Subject: AB/75/20/PL. AB/76/20/PL

Please find below my objection to the plans AB/75/20/PL. AB/76/20/PL

Existing Ground Floor Plan

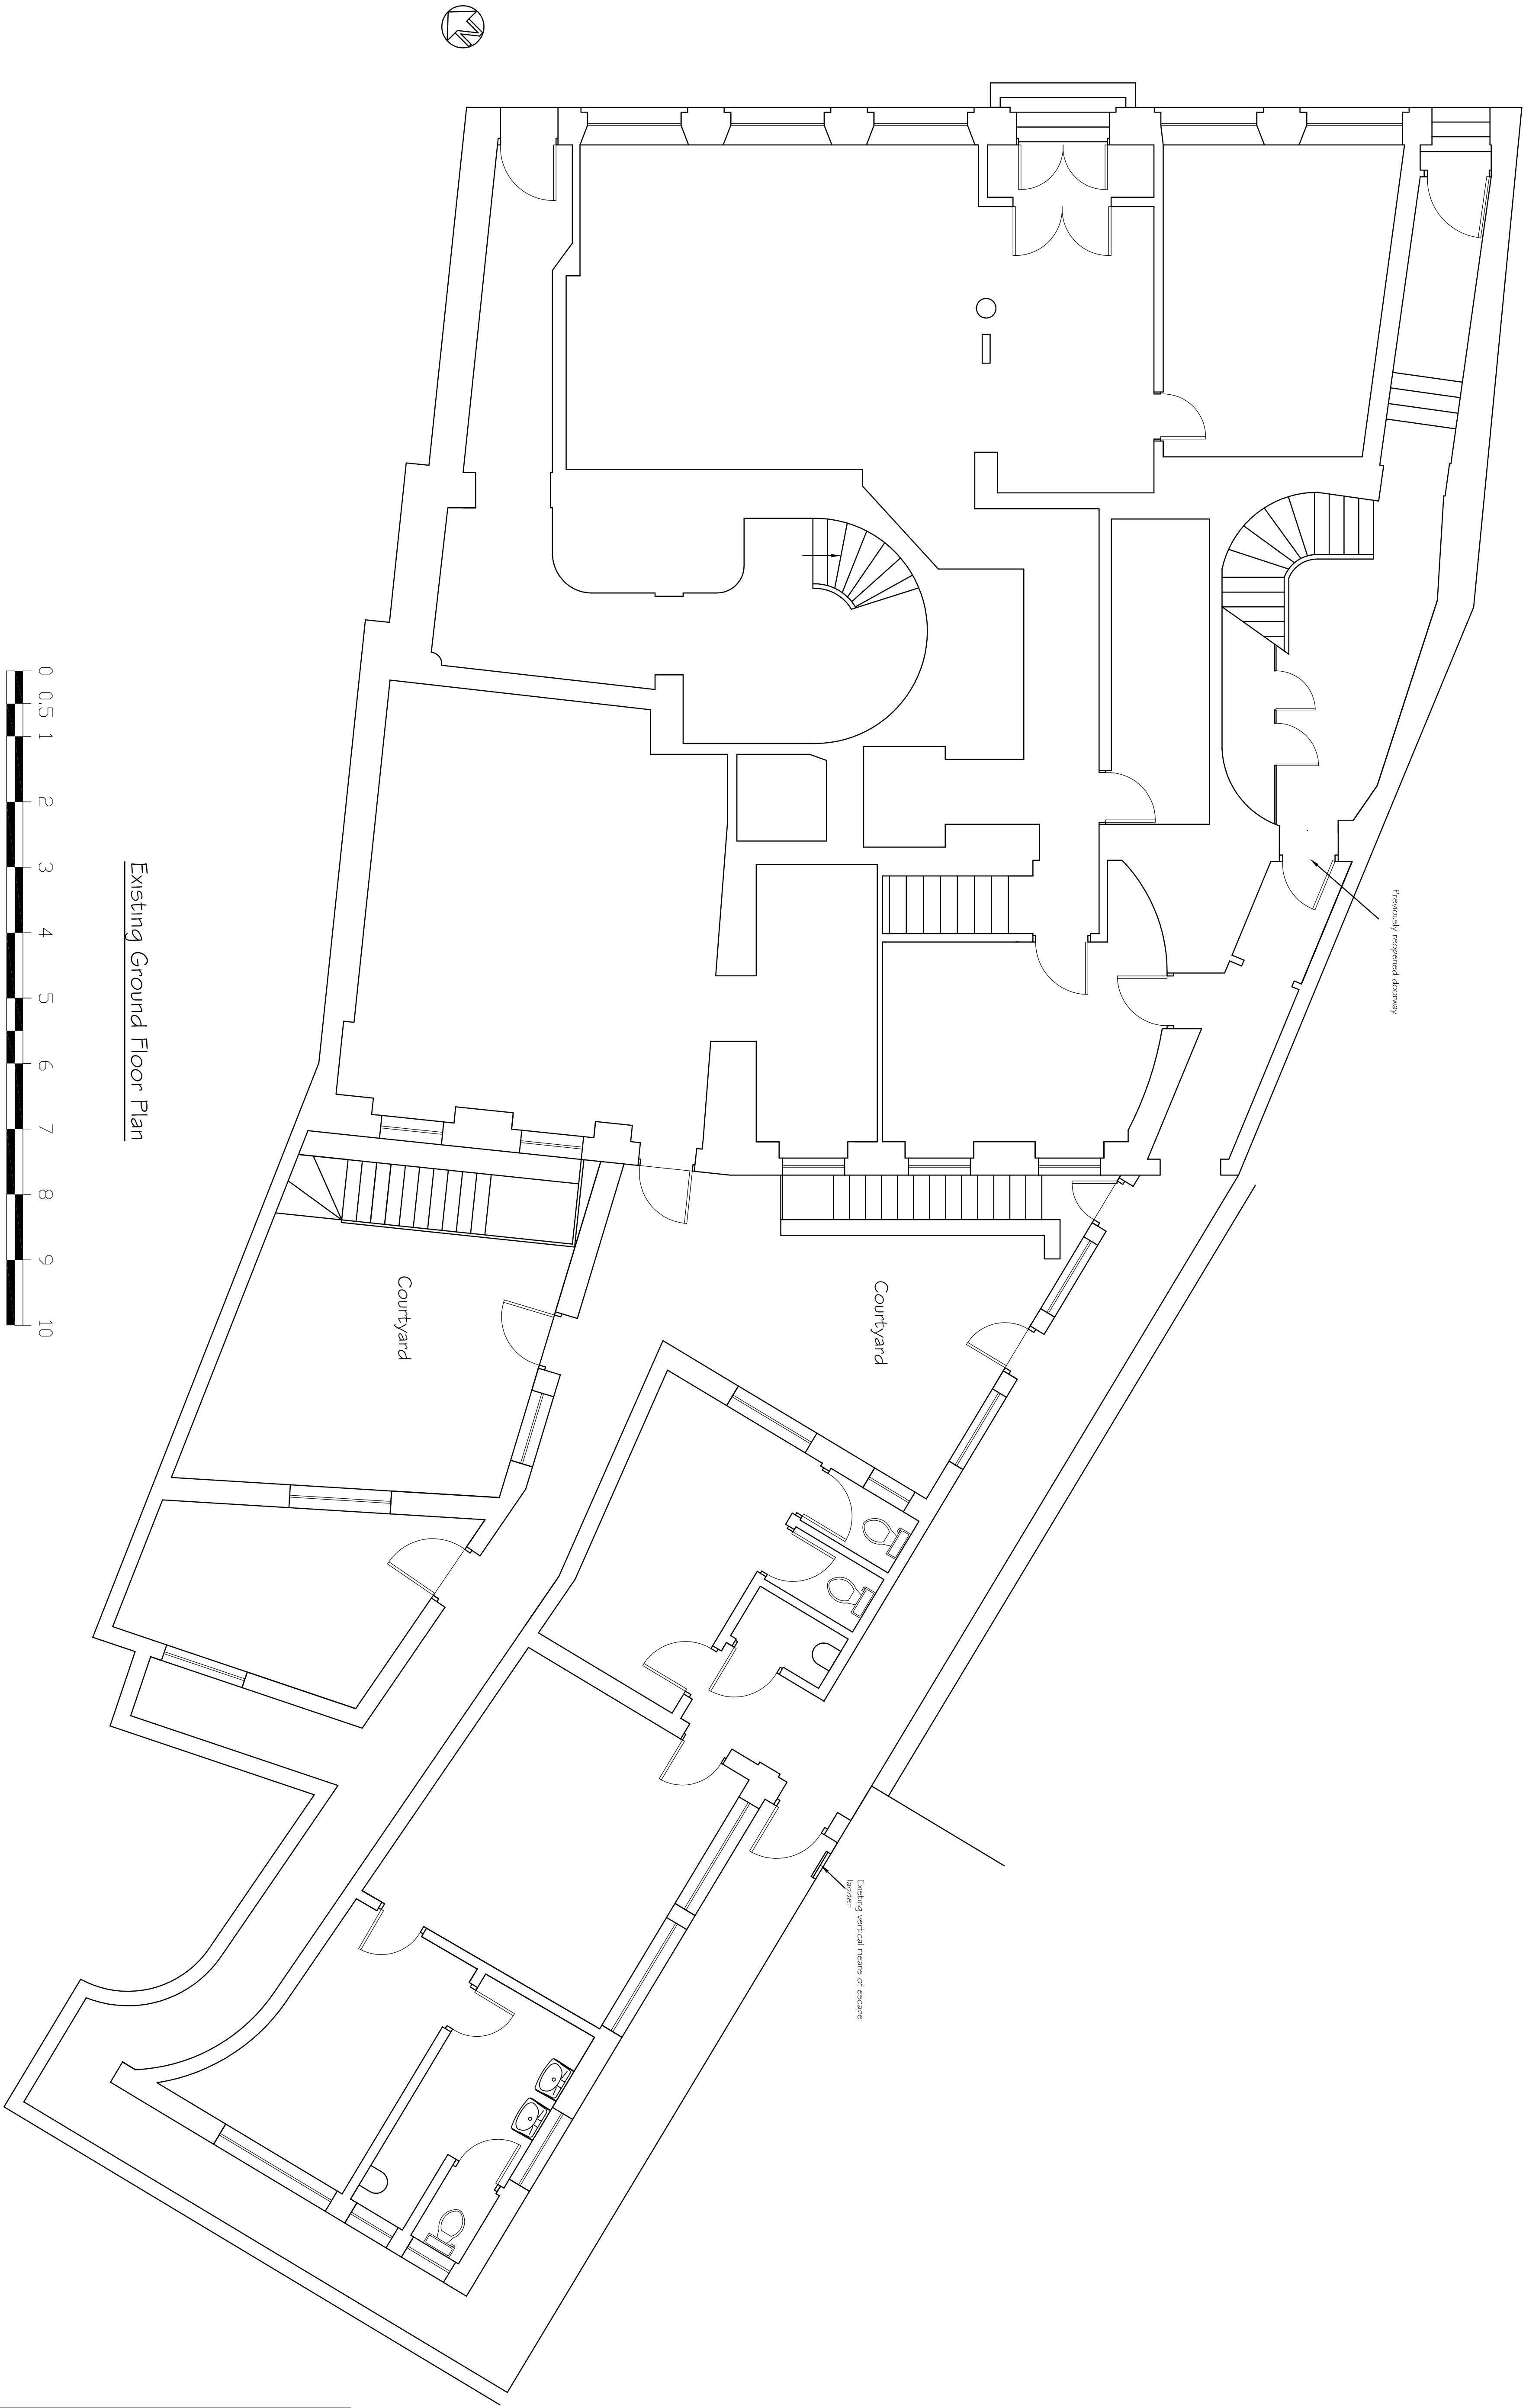
Mr Meredith does not reside in Arundel and has no respect for this building and without warning to the residents or any permission from the Listed buildings department or Arun District Council viewed himself above the law and smashed an opening at ground level in the communal area of 55a under the listed cantilevered staircase. This act was carried out on the 28th May 2020 but I note that on the planning portal application document Part 4, it incorrectly states that works began 20th June 2020 which is a blatant untruth.

Additionally box 6 is incorrect as a partial demolish of an internal wall that contained 2 layers of bricks occurred, with no structural engineers report undertaken where all the evidence suggests that those bricks had been present since 1962. The application and works are negligent in that they do not specify what compensating structural support has been or should be added.

## Proposed Ground Floor Plan

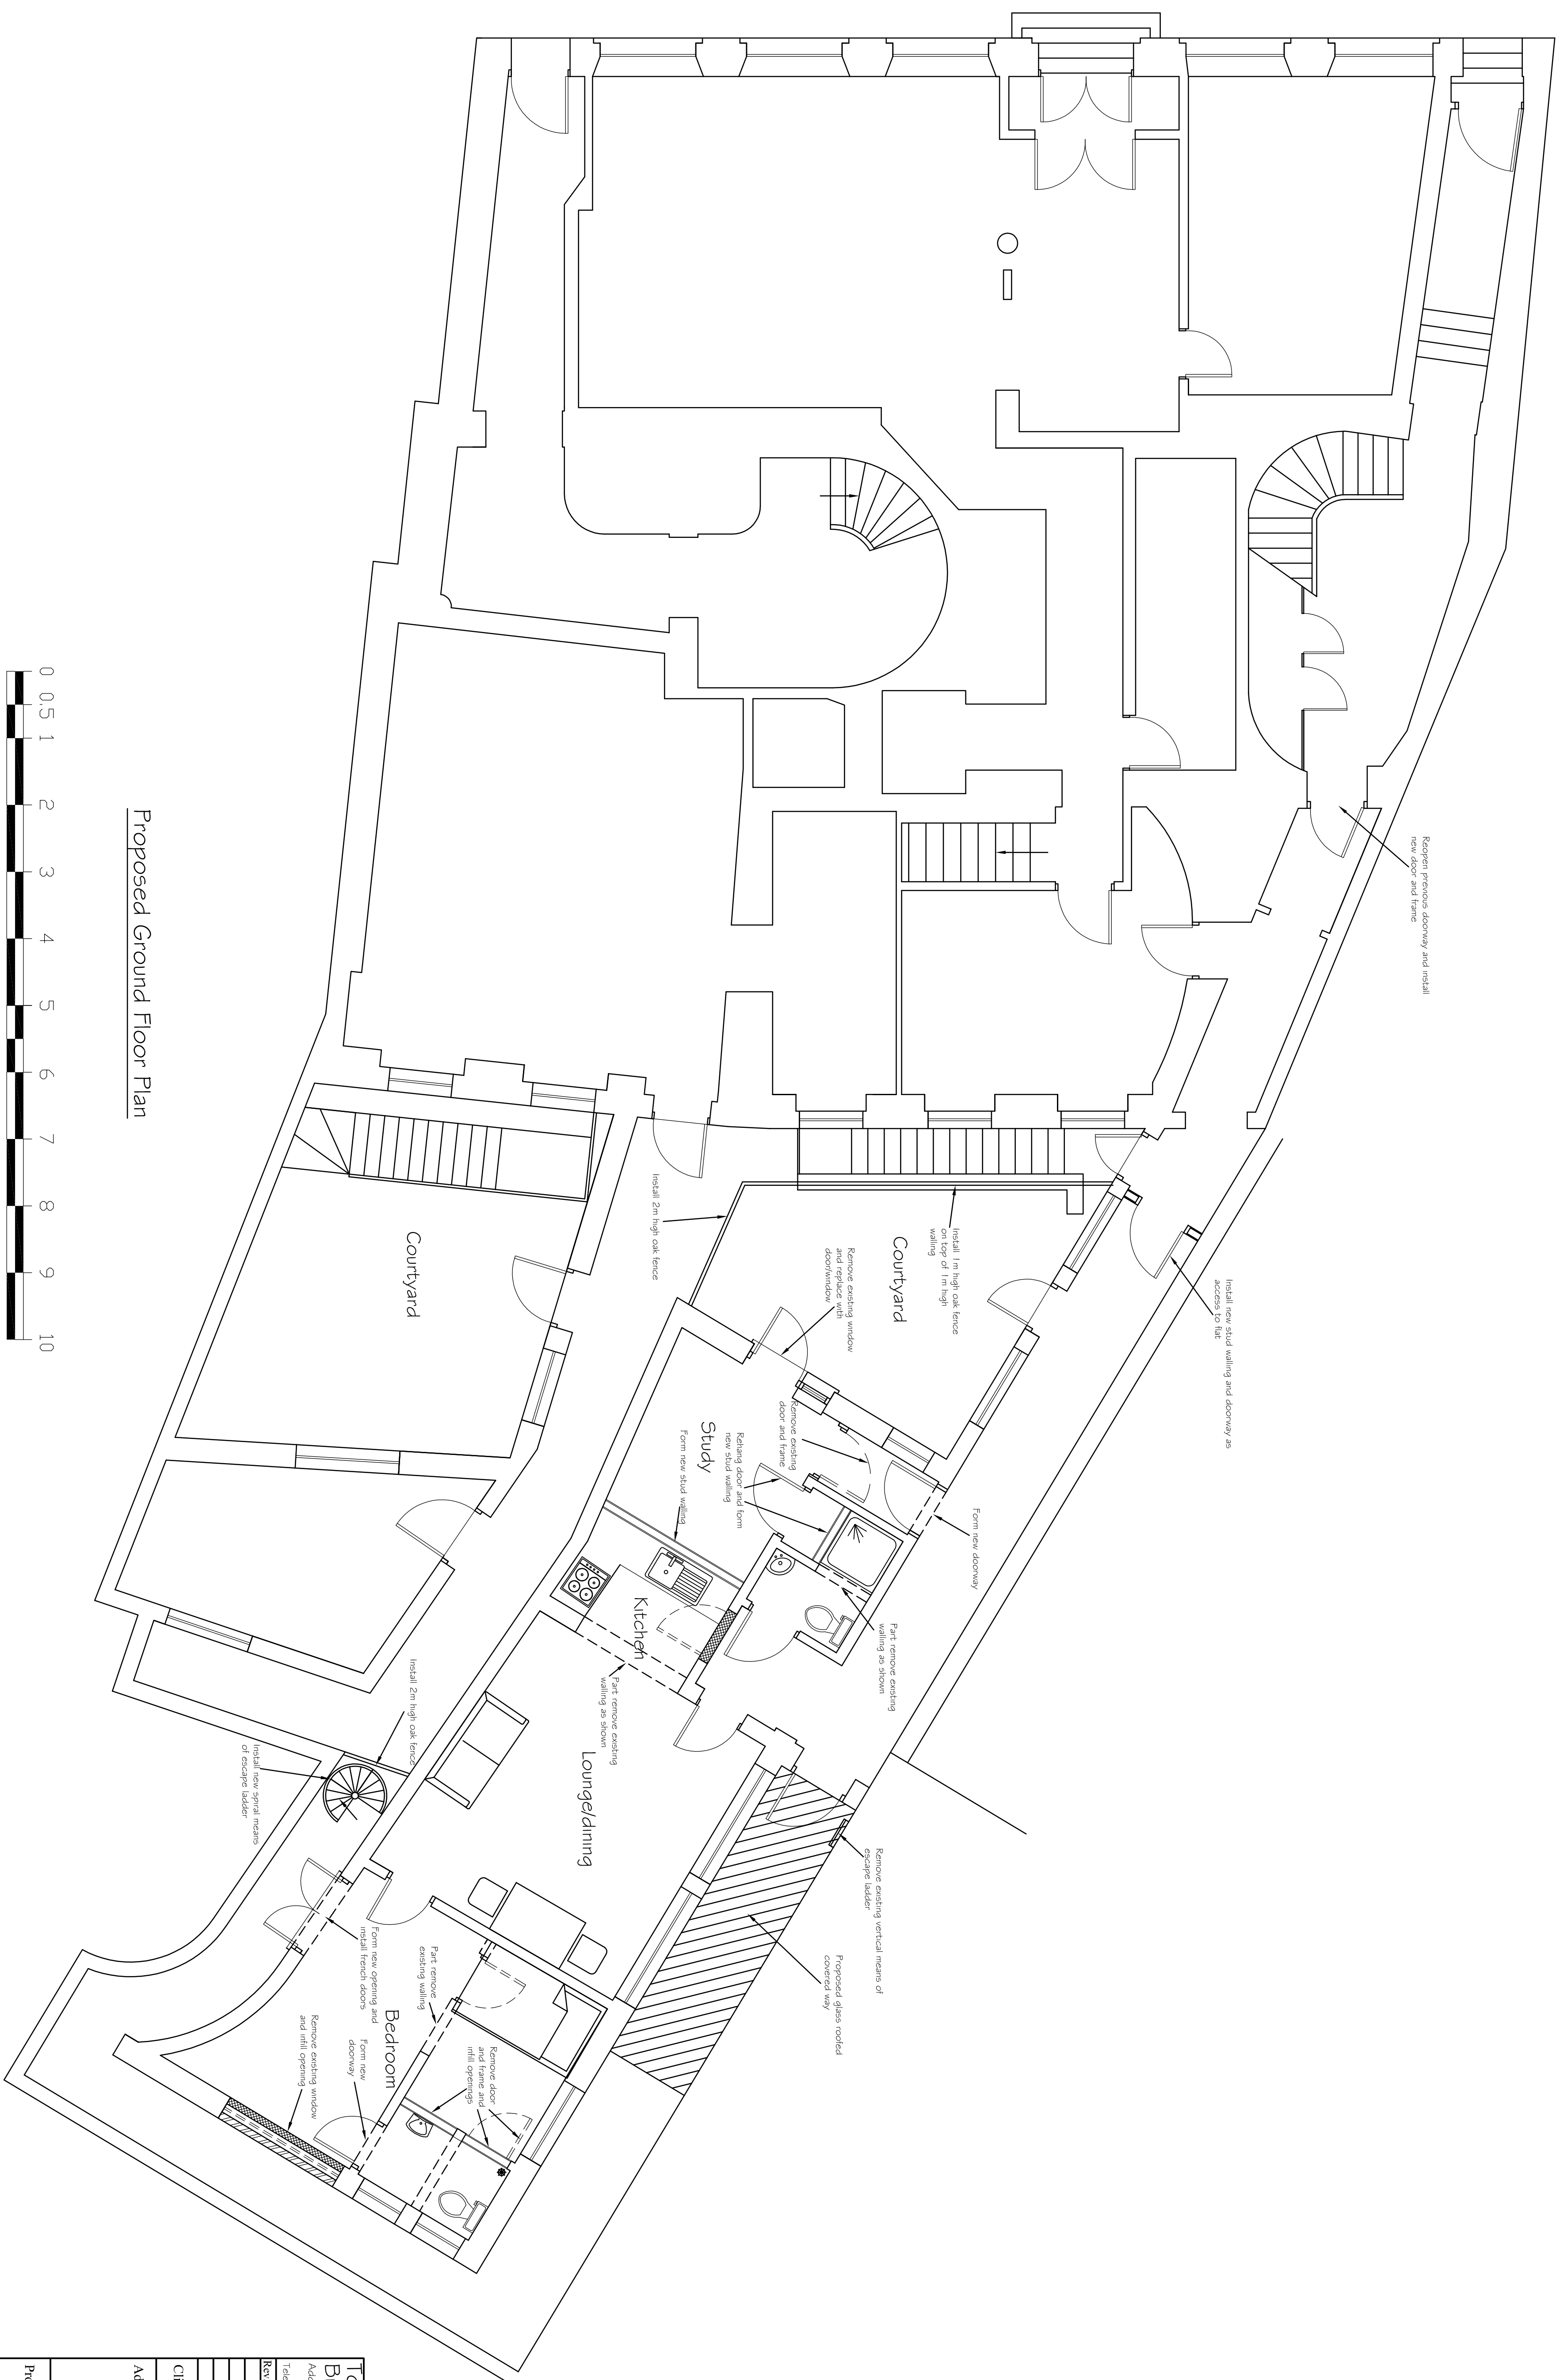
Additionally, Mr Rogers, the applicant's agent has submitted a ground floor plan that claims to be 1:500 scale. A similar size plan was provided by Victoria Holland under AB/48/17/PL which is actually a scale of 1:100. It should be noted that the space surrounding the annex is probably only 1 metre wide. Therefore I doubt the total plot size calculation is correct. This dwelling 3/4s surrounded by high walls almost within touching distance and directly overlooked by 8 dwellings ; which would make for a joyless setting concluding an unequivocal over intensive use of this site.
